Memorandum

Re: Mixed Use Development at 321 Commercial Street; Level III Site Plan/Subdivision, J B Brown & Sons, Applicant.

Project #: 2012-615 **CBL:** 40-E-3

DEMOLITION PLAN

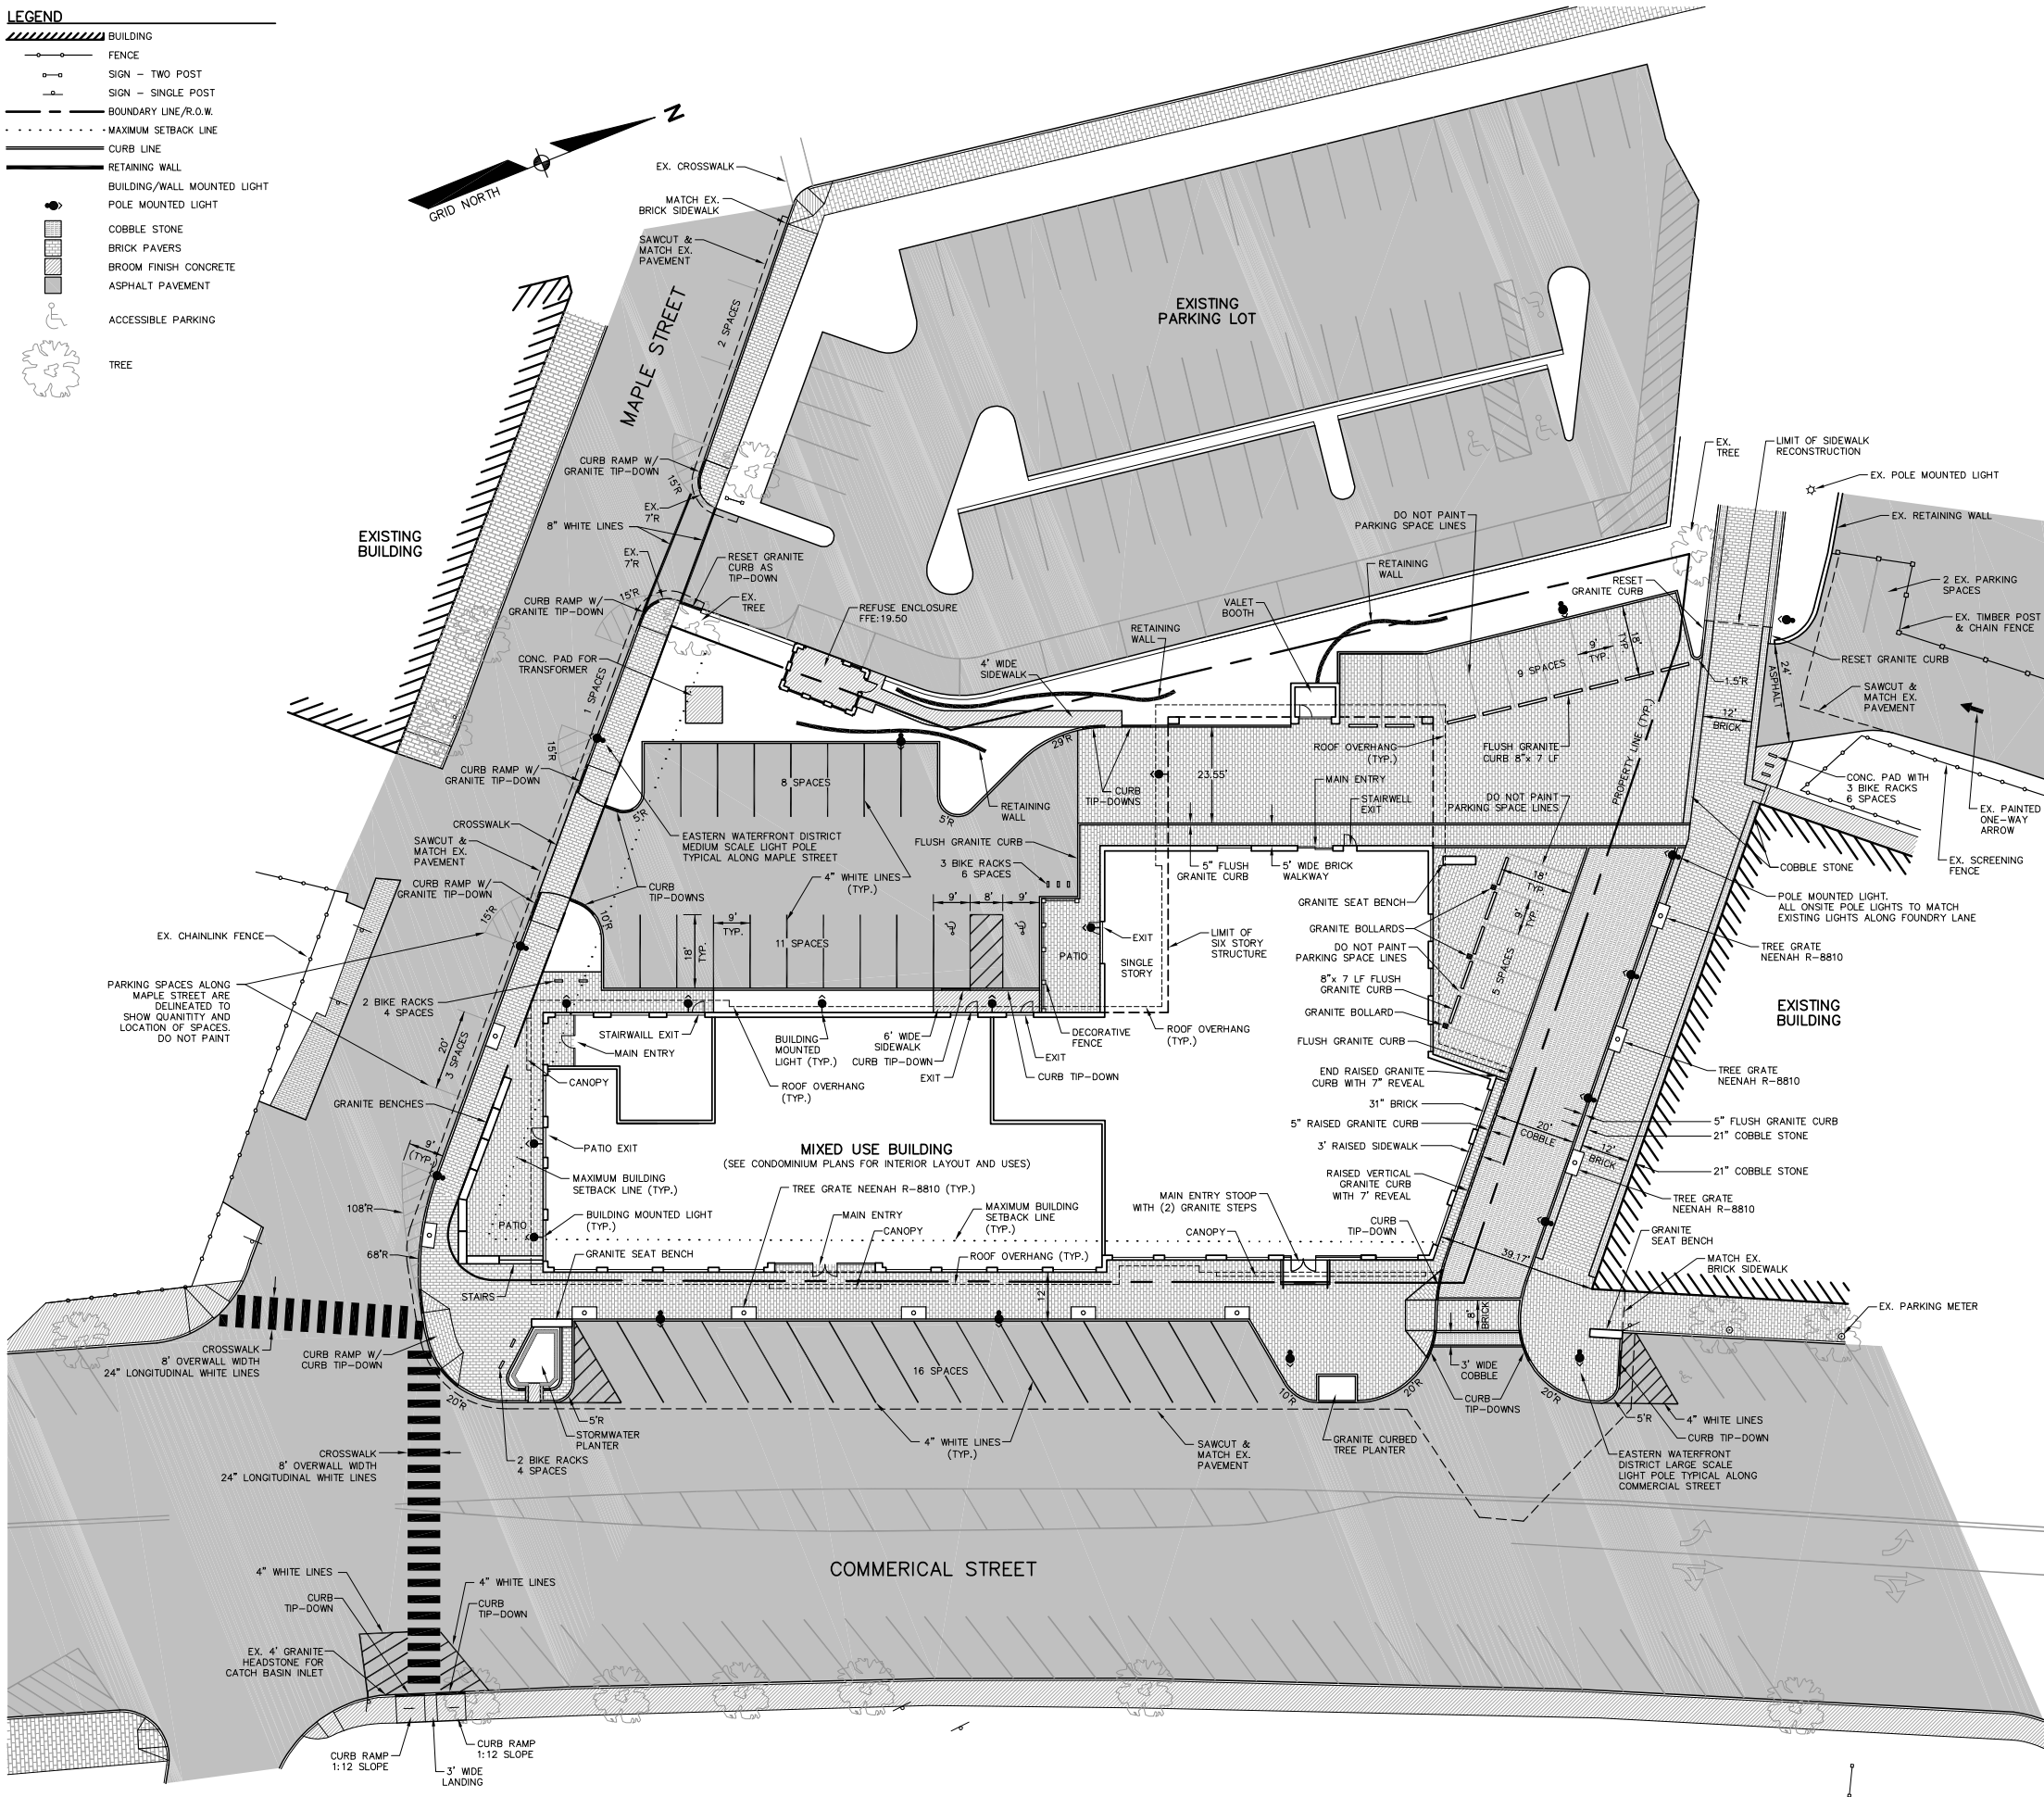
There are about 13 existing small street trees along Maple Street, Commercial Street and Foundry Lane that appear to be removed

by the proposals, although not all are shown on the Demolition Plan (Attachment Plan 5). The four trees along Maple Street (near York Street) are more substantial and are proposed to be removed to allow for a new brick sidewalk (see discussion re *Sidewalks* below).
